**Planning Department
Transportation Development Services**

**Re: McDonalds, 6300 San Mateo Blvd.
Traffic Circulation Layout**
Architect's Stamp dated 11-05-14 (E18-DO19C)

Based upon the information provided in your submittal received 11-07-14, the above referenced plan cannot be approved for Building Permit until the following comments are addressed:

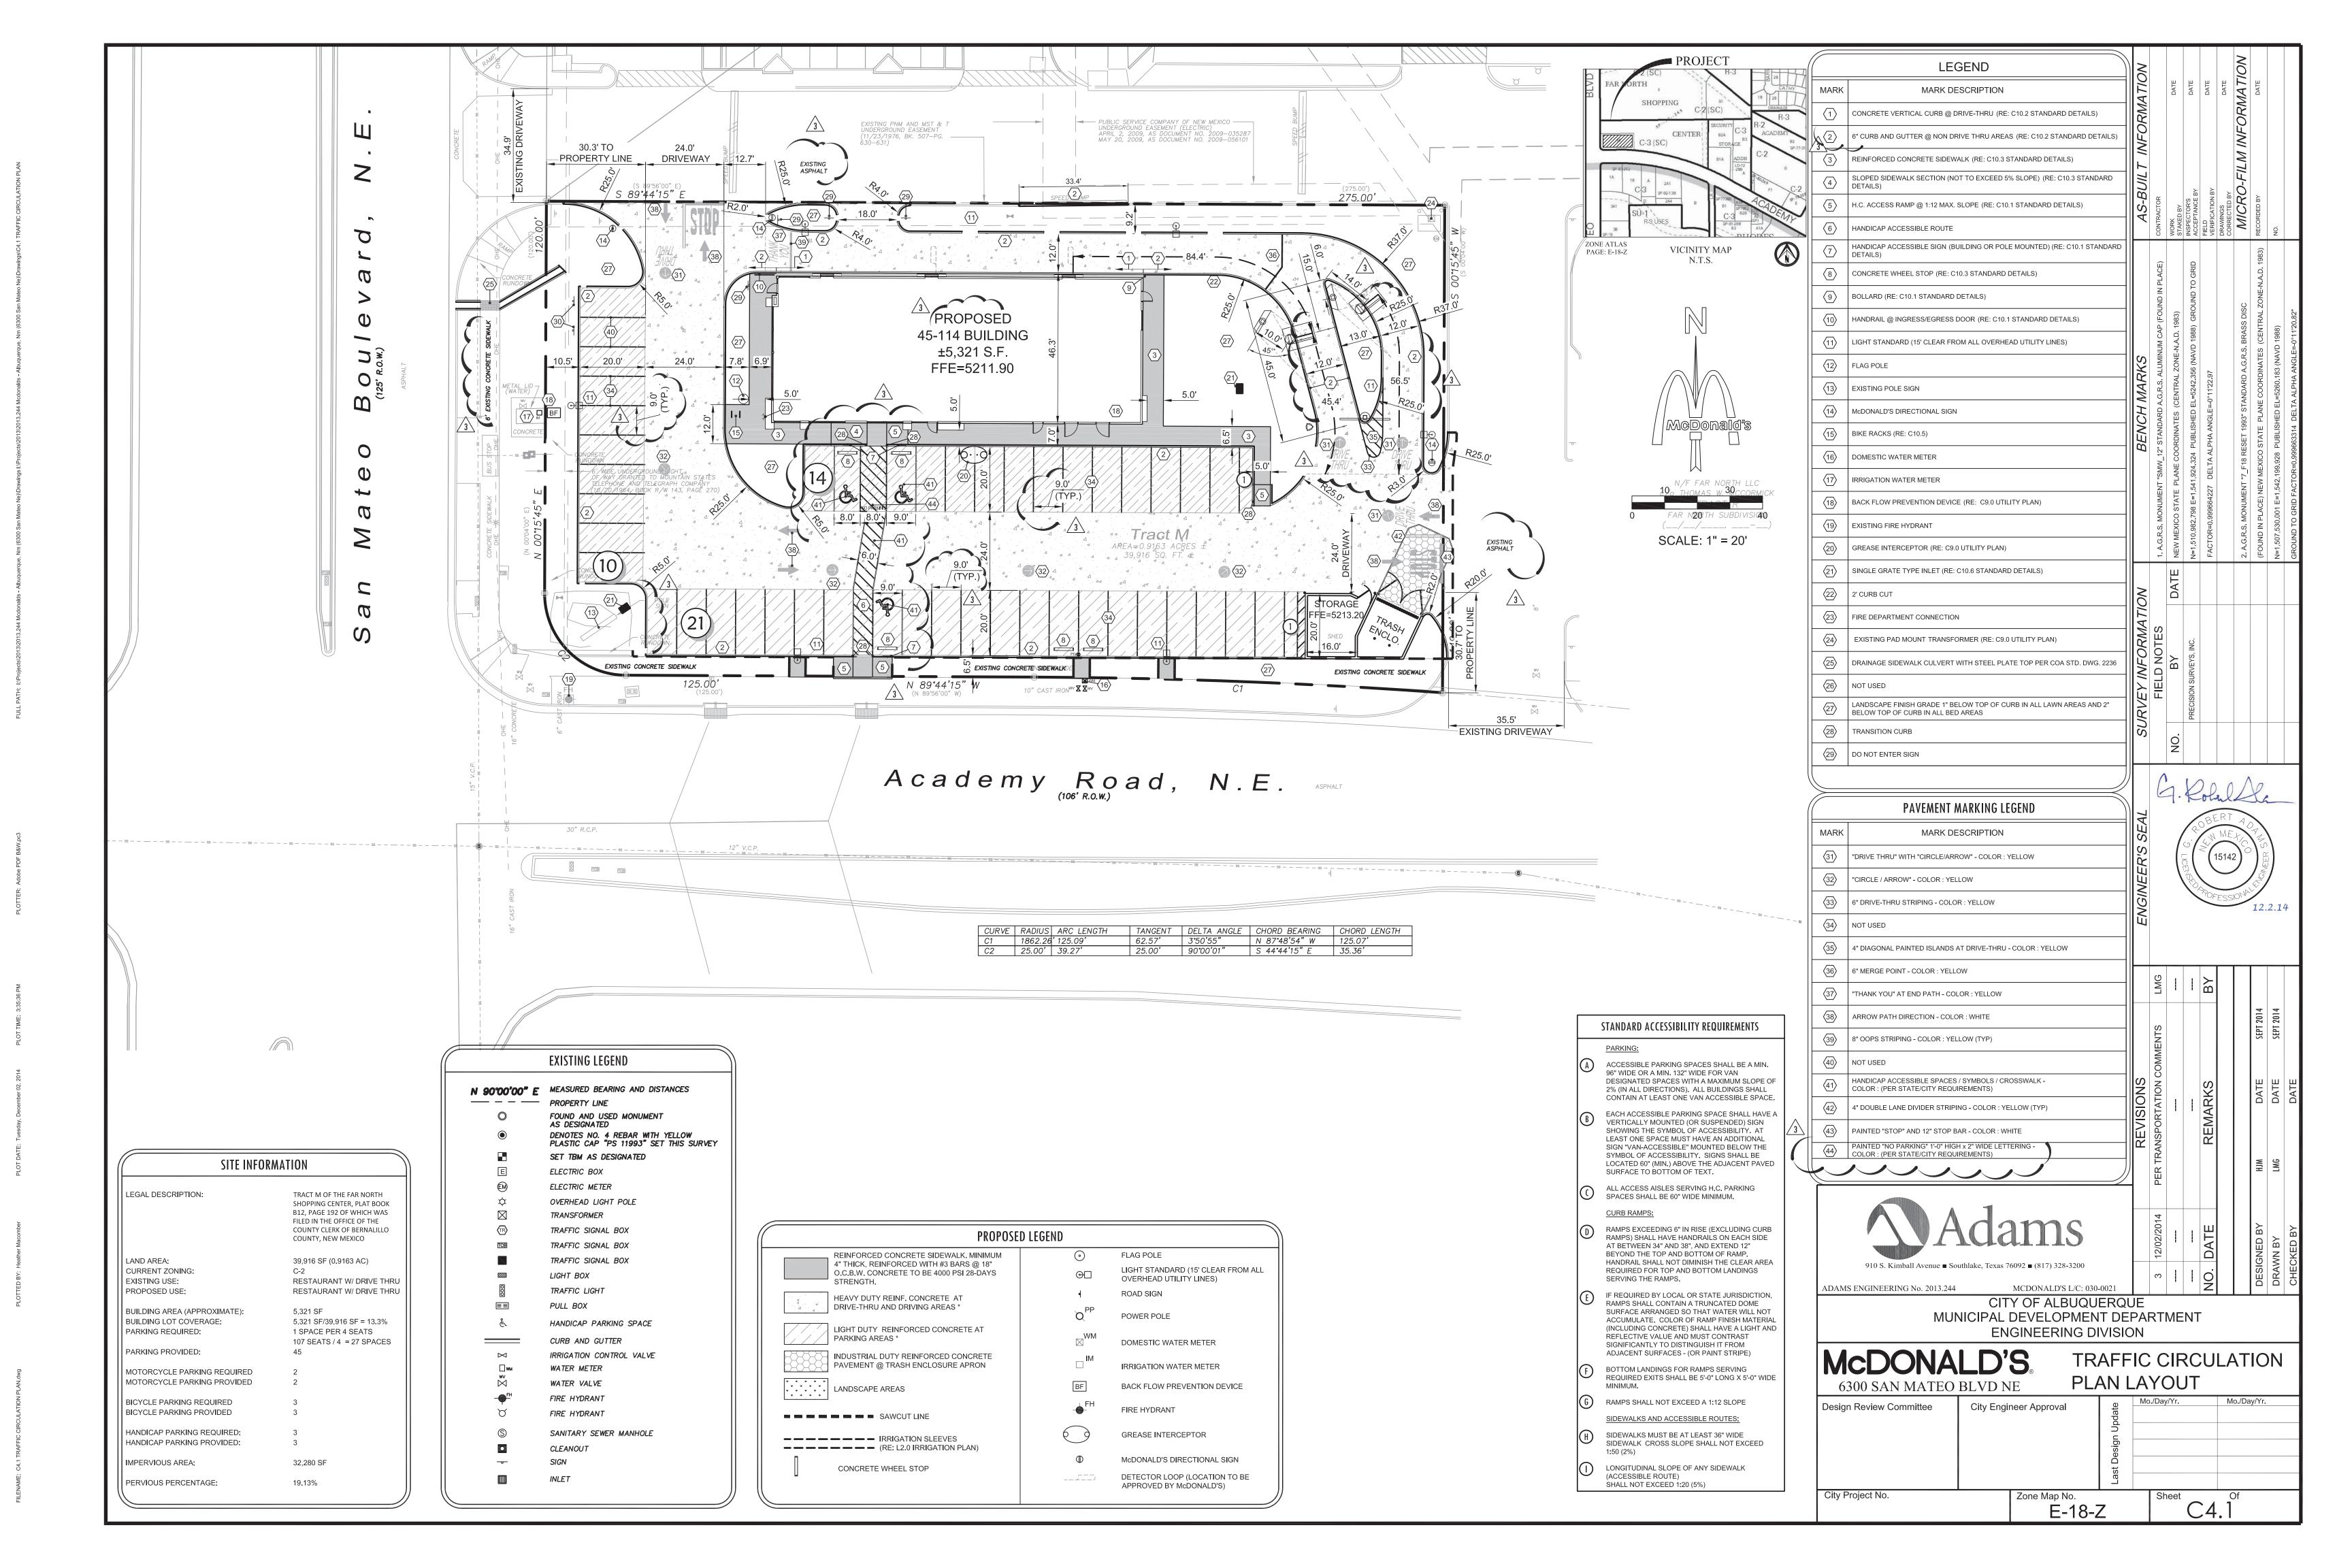
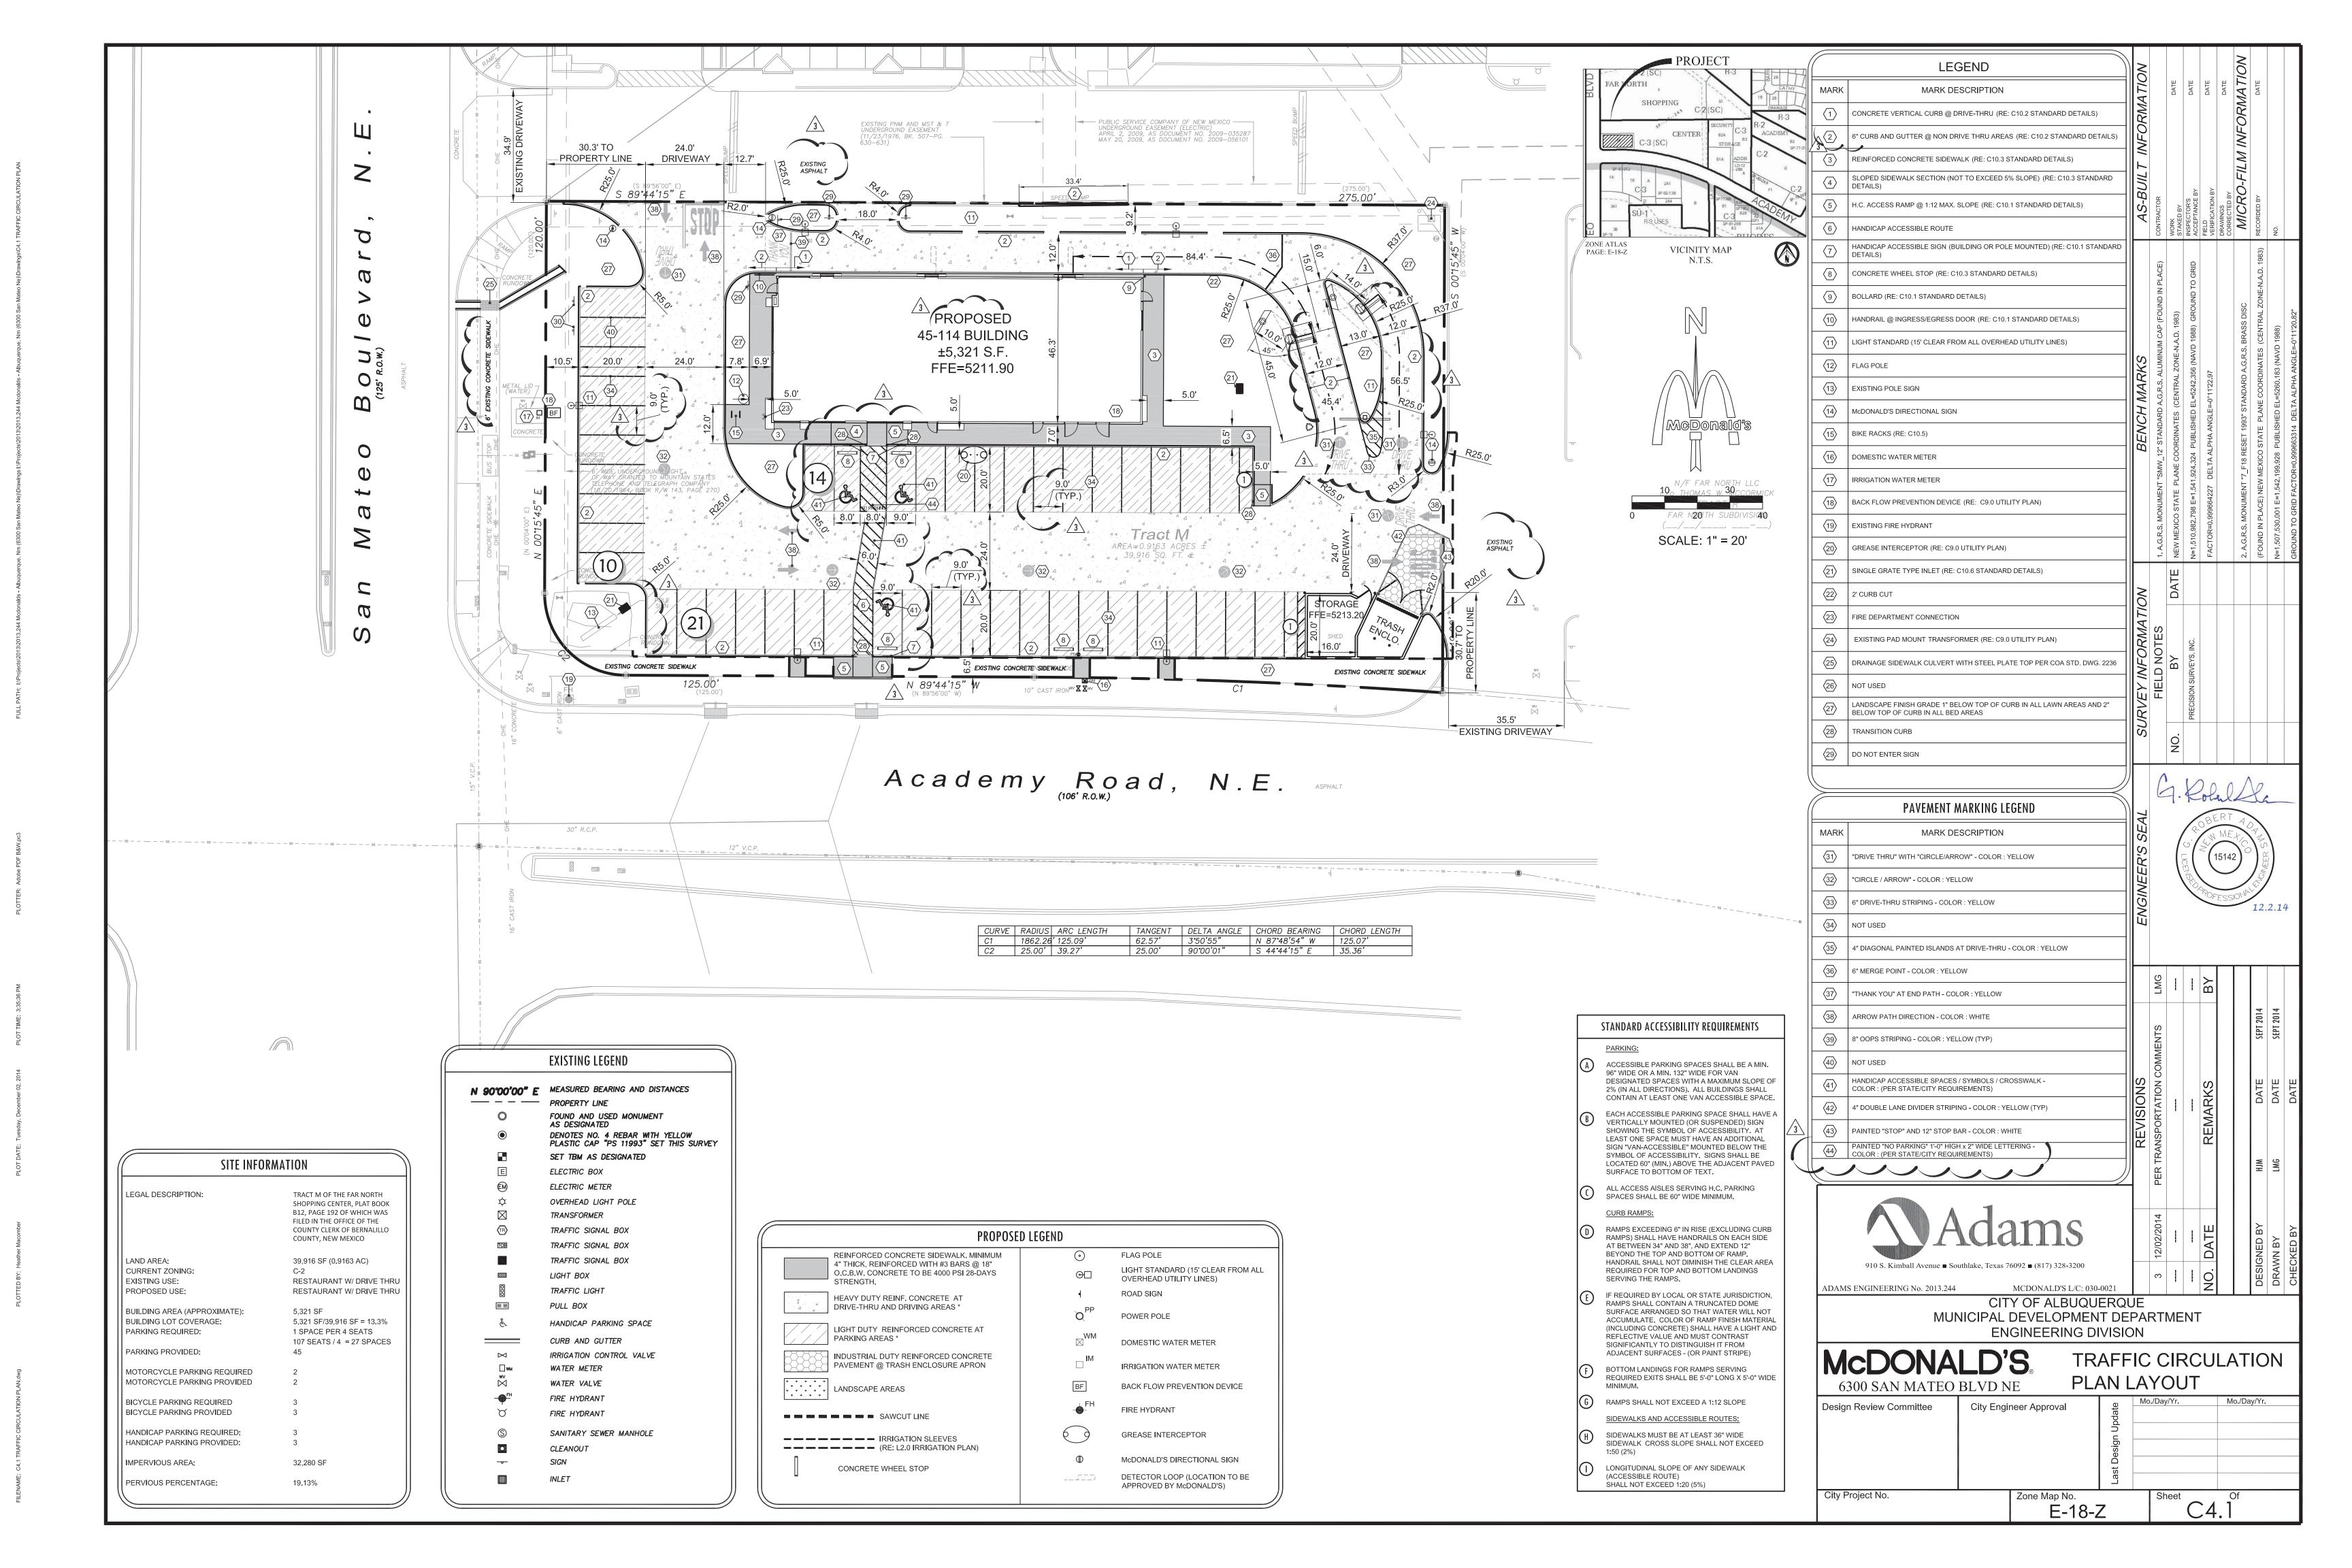
1. Label the McDonald's building as existing. Label width of existing sidewalk along San Mateo Boulevard. If some of the existing curb on the site is to remain, label the existing curb and curb height. (The curb height should be between 6 inches and 8 inches.)

2. List the width for all parking spaces. The minimum width for the parking spaces should be 8.5 feet. Also label the width of the handicap space on the south side of the parking lot.

3. The handicap accessible spaces must include an 8-foot wide van access aisle. Currently, the aisle shown is only 5 feet. Also, label the striping for the handicap accessible aisle and pathway.

4. Include an ADA van accessible sign. This sign must have the required language per 66-7-352.4C NMSA 1978 **"Violators Are Subject to a Fine and/or Towing."** (Provide sign detail on Sheet C10.1 as called out by Keyed Note 7 on the plan sheet.)

5. The 8-foot wide ADA access aisle shall have the words **"NO PARKING"** in capital letters, each of which shall be at least one foot high and at least two inches wide, placed at the rear of the parking space so as to be close to where an adjacent vehicle's rear tire would be placed. (66-1-4.1.B NMSA 1978)

6. Per the DPM, a minimum 6-foot wide ADA accessible pedestrian pathway is required from the public sidewalk to the building entrances. Please widen the existing handicap accessible pathway shown tying into the existing sidewalk at

7. A 6-inch to 8-inch high curb is required to separate the driving area and parking lot from the sidewalk and landscaped areas. Label the new curb as 6 inches or 8 inches.
8. Label both existing and proposed asphalt for the new parking lot.
9. Show the queue length for the drive-thru.
